Our Ref: PDJB/2412

13 June 2025

PLANNING APPLICATION – 2025/91221 – FORMER HSBC, 2 CLOTH HALL STREET, HUDDERSFIELD

We are writing further to our exchange of emails regarding the above application. We have considered the planning concerns raised in your email of 10th of June, and have addressed each issue within the amended plans that accompany this letter. To assist, we will set out the amendments we have made to the layouts.

FIFTH FLOOR PLAN

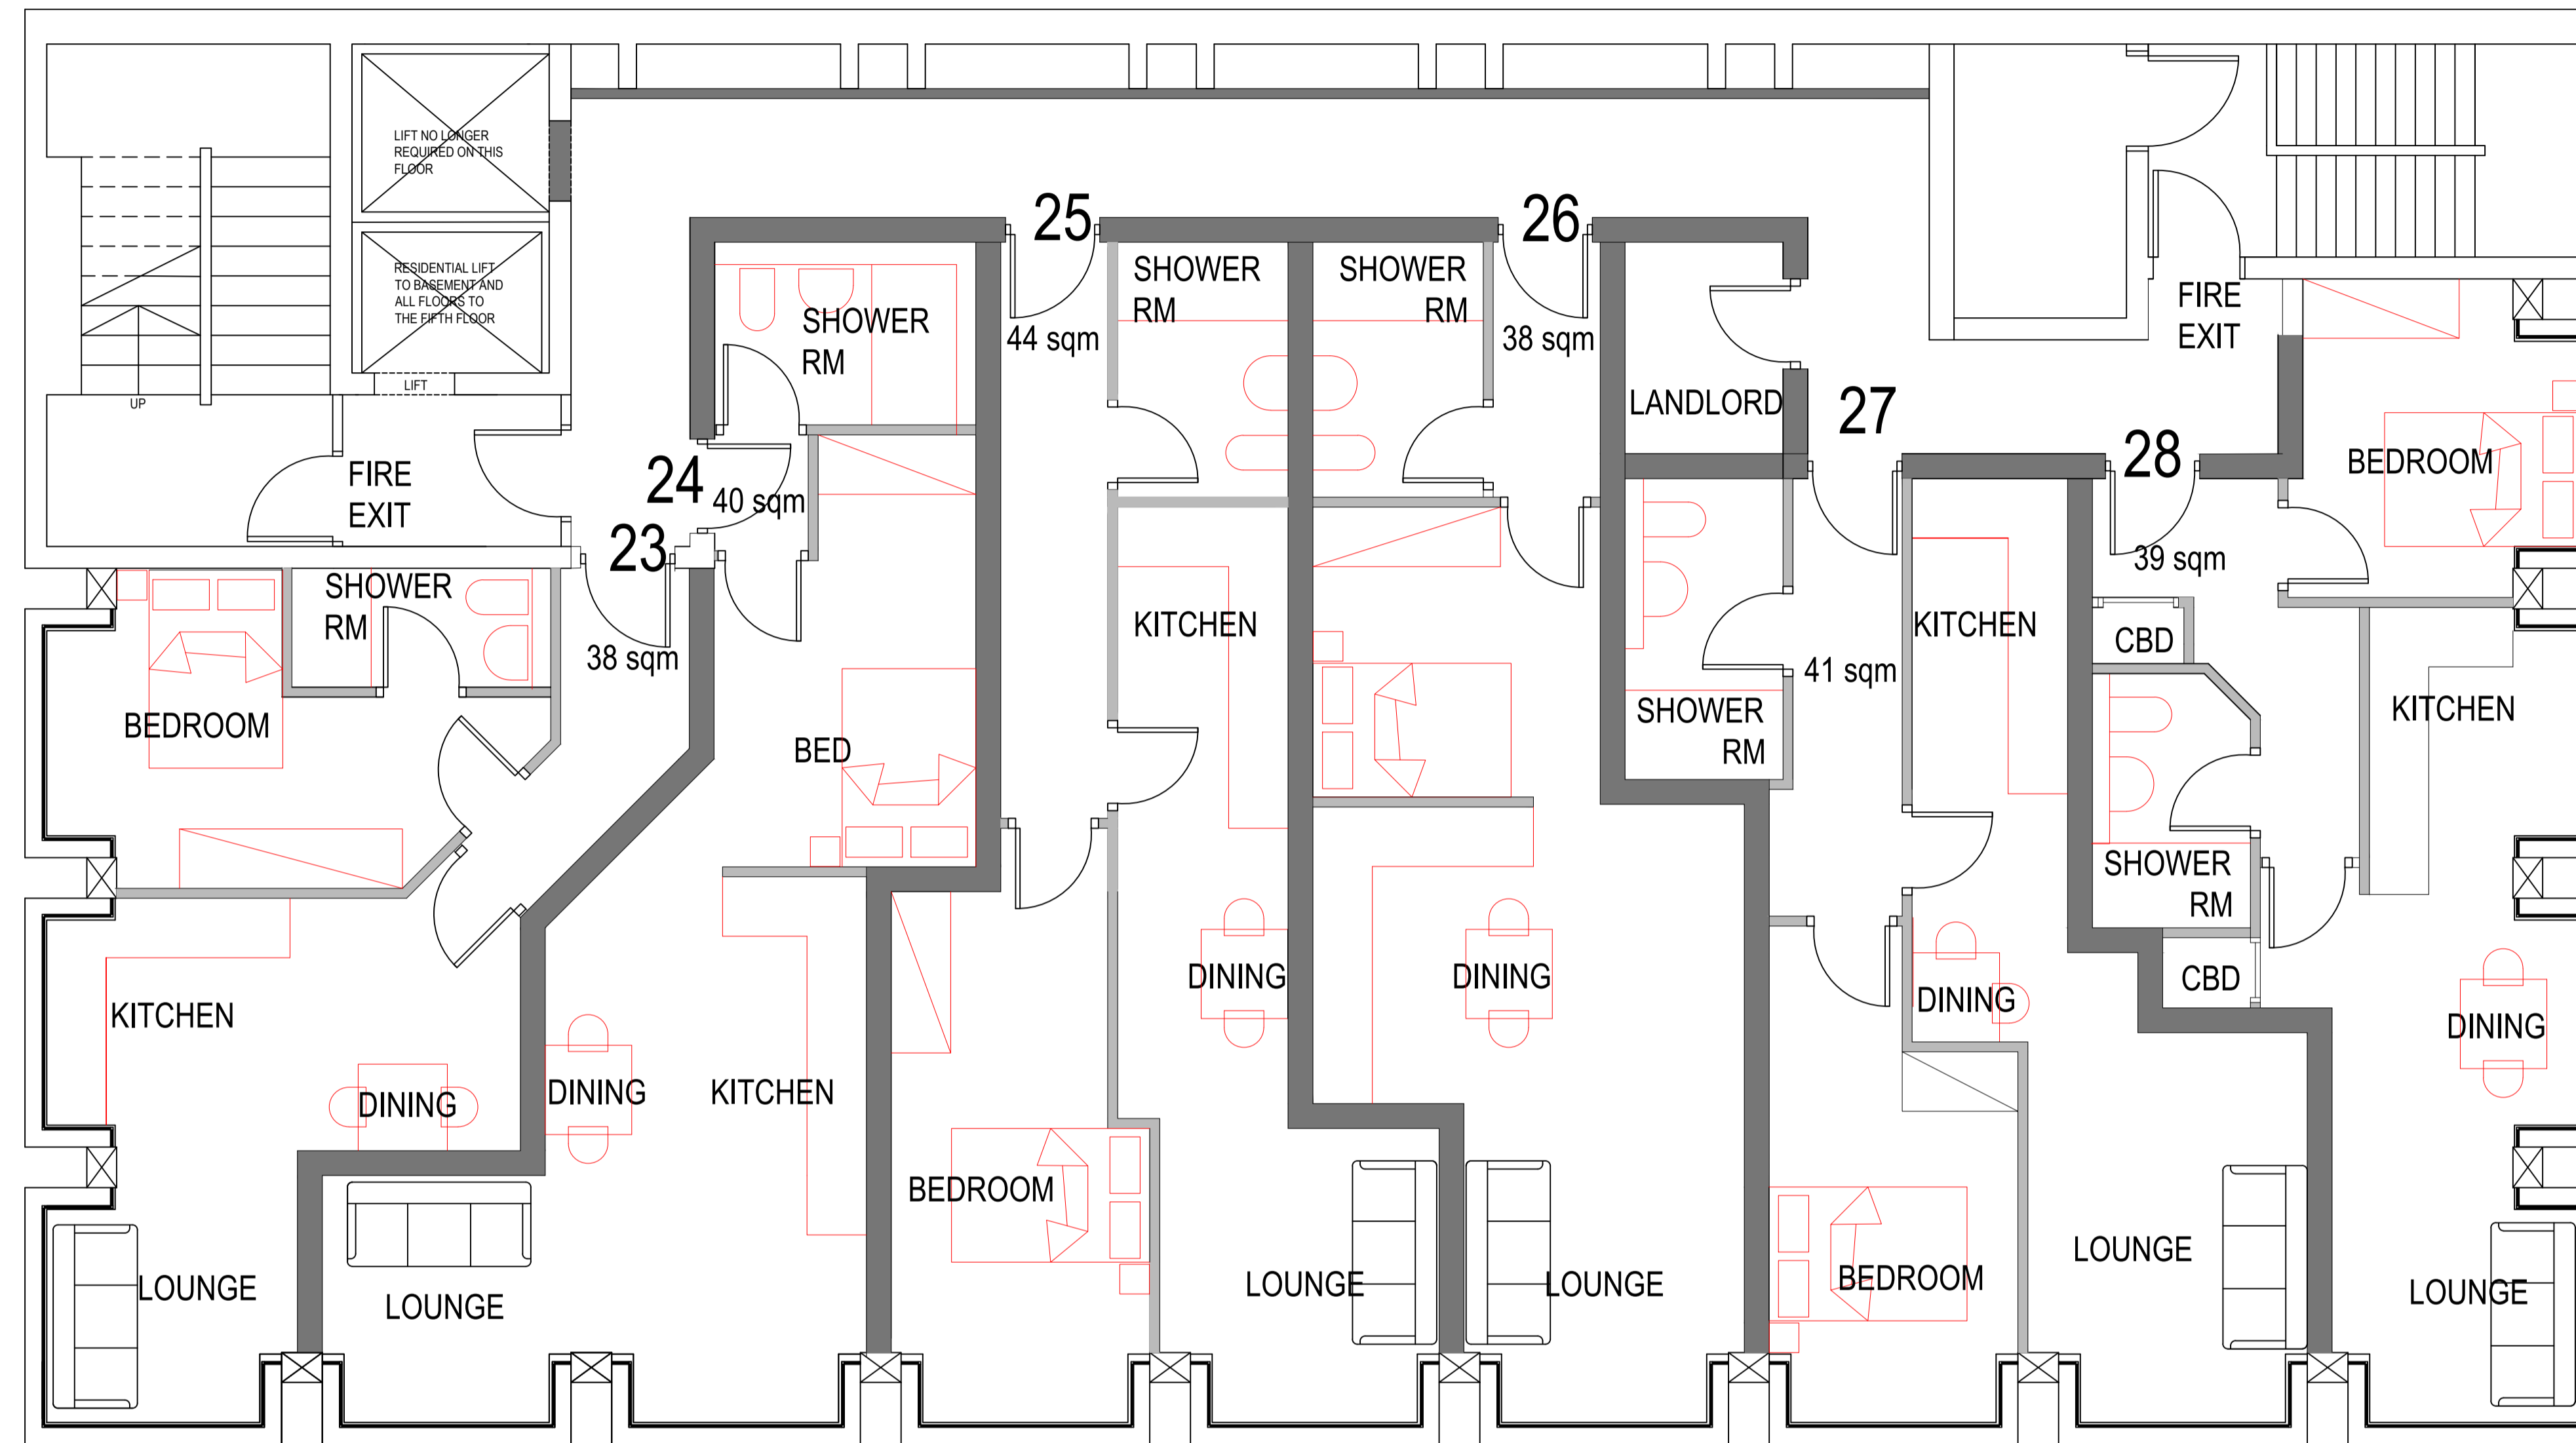
These units have all been re-designed to ensure the bed and dining areas benefit from better levels of natural light provided by the existing glazed bays.

The dining areas have been relocated to ensure improved levels of natural light.

SIXTH FLOOR PLAN - PLANT ROOM 1:50

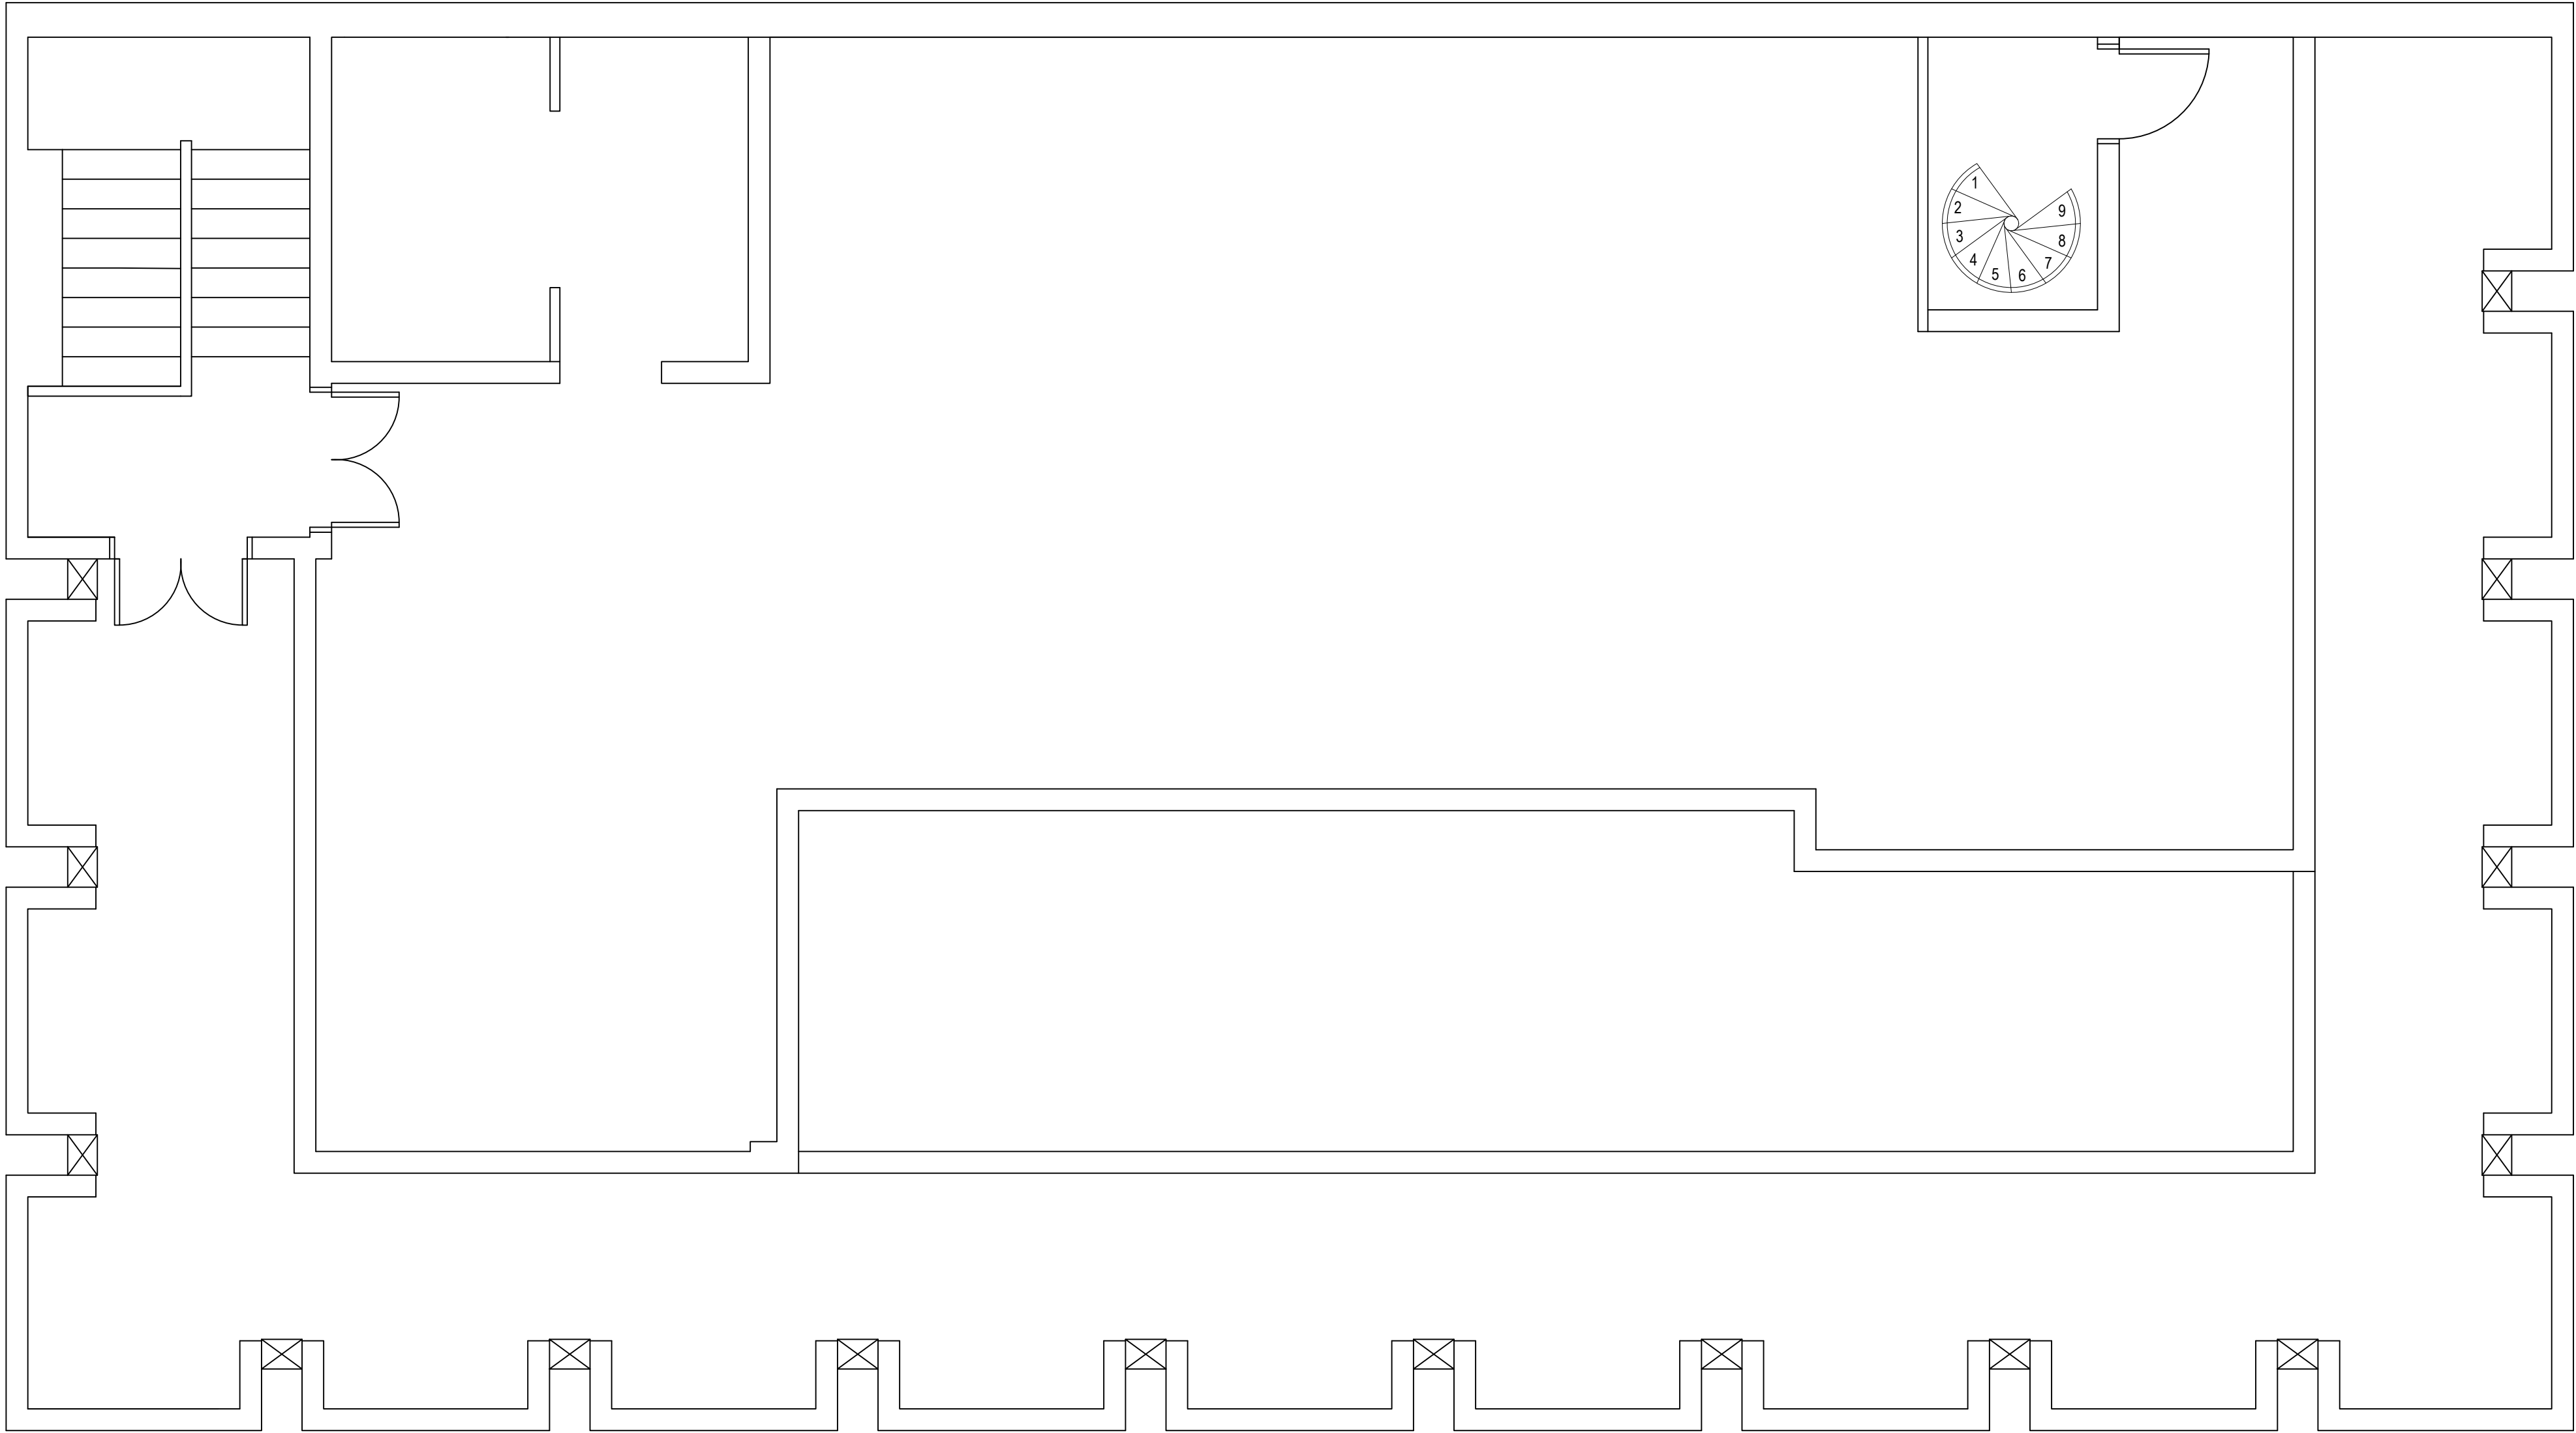
1.19 – A note has been added to the sixth floor plan. This floor currently houses the plant that served the former bank use. This area provides ample accommodation for water tanks etc to serve the sprinkler system.
